Your Ref: OWPC327
Our Ref: LY/10/13/
Please ask for:
Mr D Sullivan

Retention of 1.83m fence, concrete post, feather edge panels at the front of the property.

10 Vicarage Cottage Lyminster Road Lyminster

MISS S POLLOCK
OLD VICARAGE COTTAGE
LYMINSTER
FENCE ELEVATIONS
SCALE 1-200

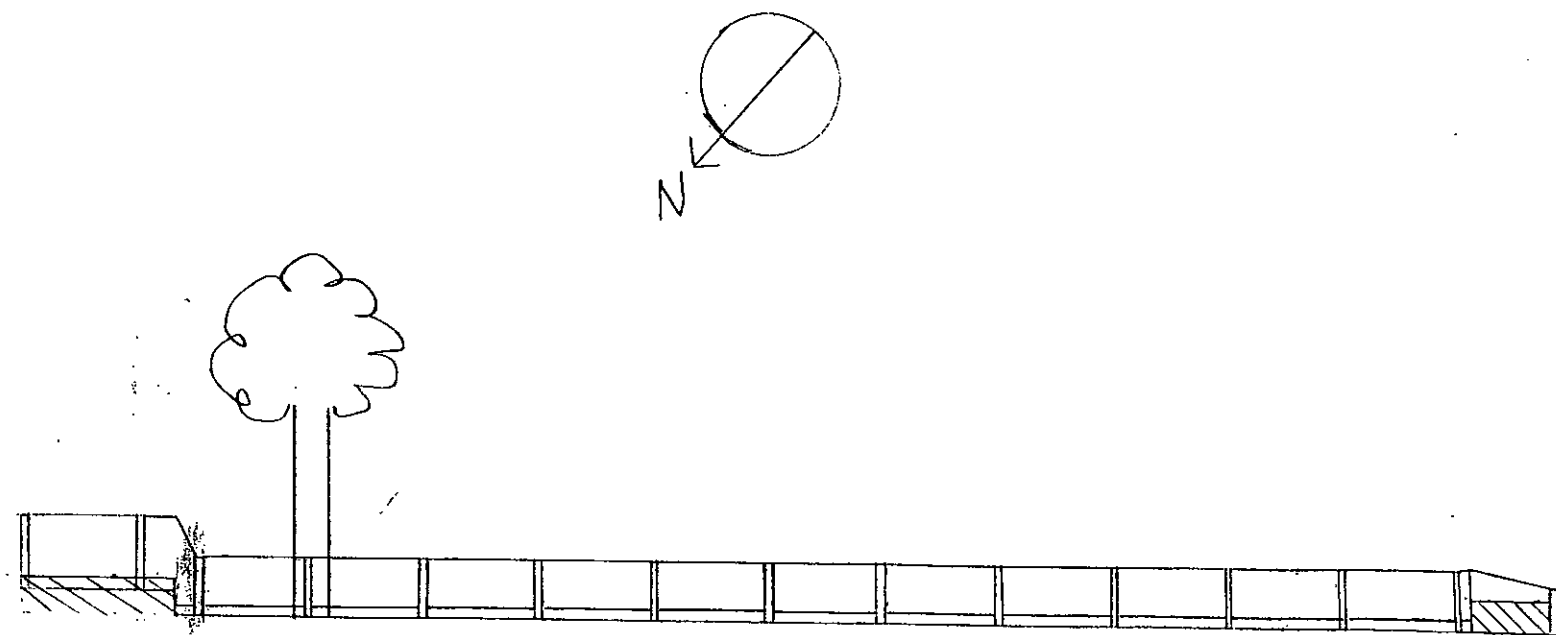
It is acknowledged that the new residents require privacy and security for their property and a wooden fence being placed outside the flint boundary wall is not only too high but also obscures the beautiful flint wall which was so in keeping with a number of neighbouring properties in Lyminster.

For the above reasons that Lyminster and Crossbush Parish Council object to the fence at its present height and position.
